From: Sue Howell
Sent: 23 July 2018 11:11
To: Planning.Responses
Cc: Anita Gardner
Subject: RE: Planning Consultation on LU/120/18/DOC

Comment from Greenspace

This application is looking for the discharge of Condition 15 of application LU/120/18/DOC

Site Address: Directors Cottage Toddington Lane
Littlehampton BN17 7PP

Scale: **AS SHOWN** Drawing No.: **17/4430/5**

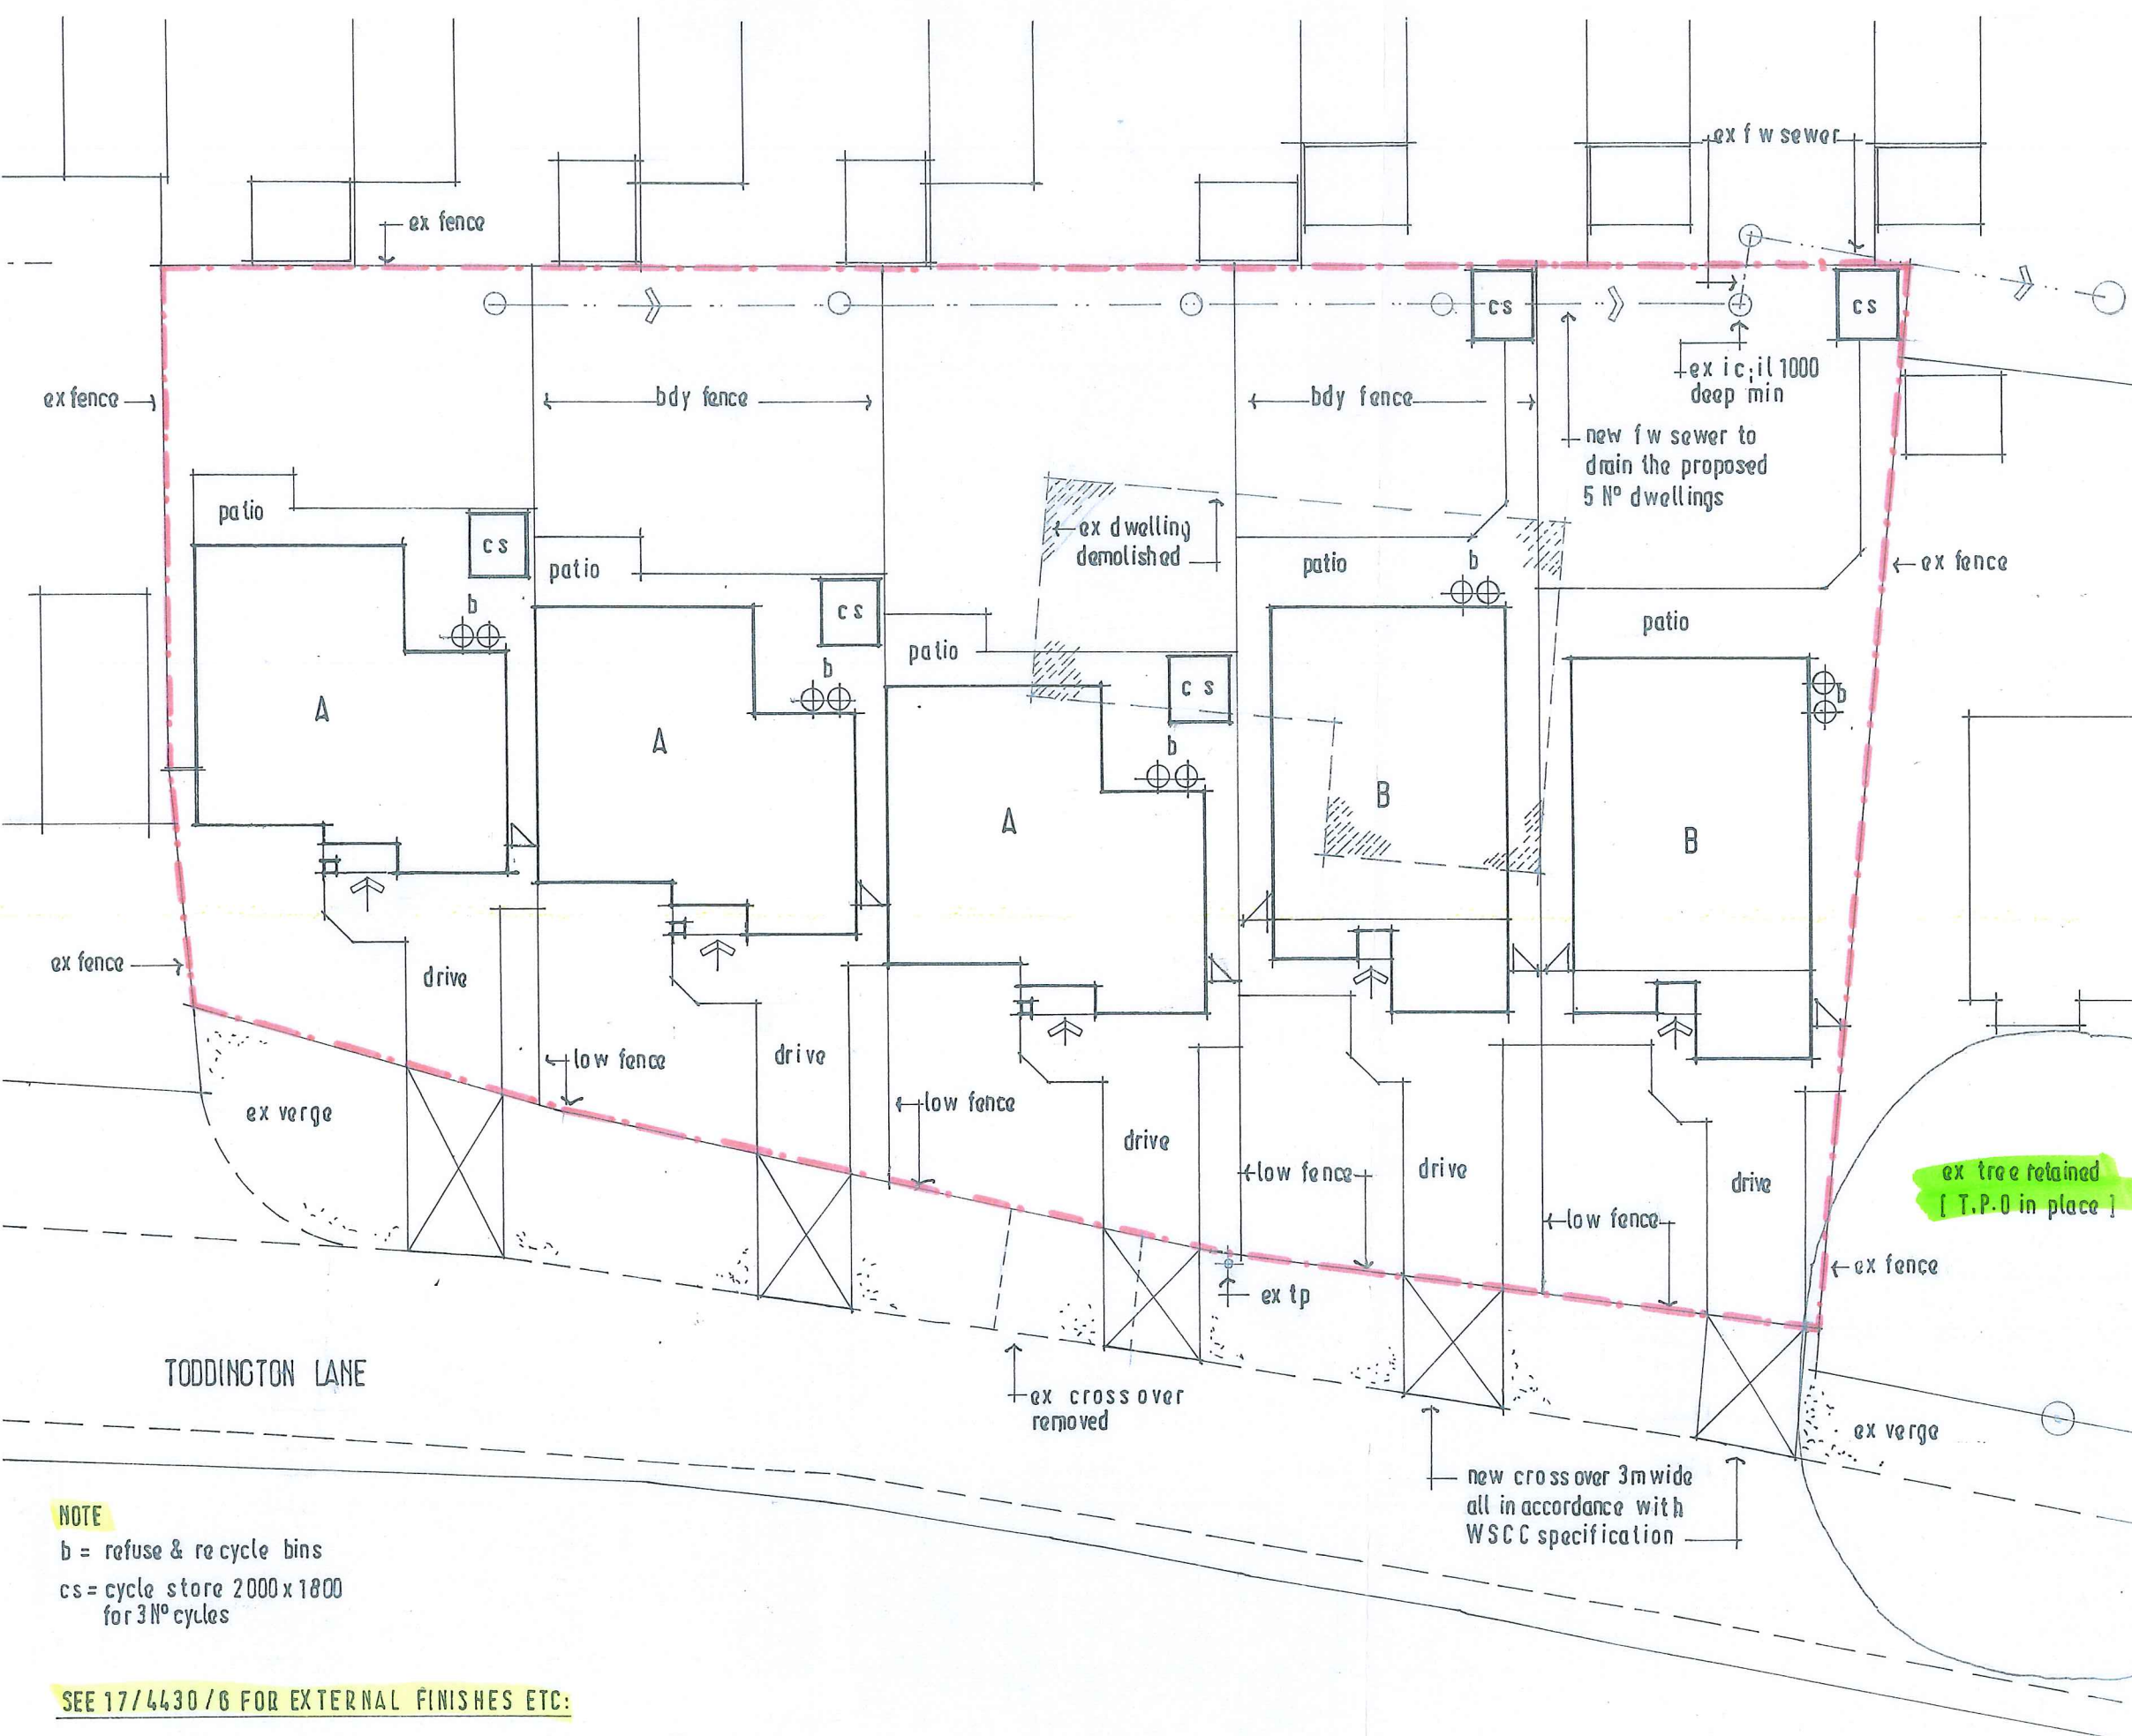
This application lists Condition 15 however no further details have been submitted re Landscape scheme and the information contained within DWG 17/4430/05 and 17/4430/16 is insufficient in detail as not providing detail in plan form of proposed trees and shrubs detailing actual quantities, species choice planting density and size at time of planting. As my previous comments, greening of new development is required to ensure that the development is fitting to location, aiding in good design, providing screening to adjacent dwellings where required and encouraging biodiversity within the site.

There is insufficient information submitted and therefore I would **not recommend the discharge of Condition 15** on application LU/120/18/DOC imposed under LU/249/17/PL until further detail is submitted for approval.
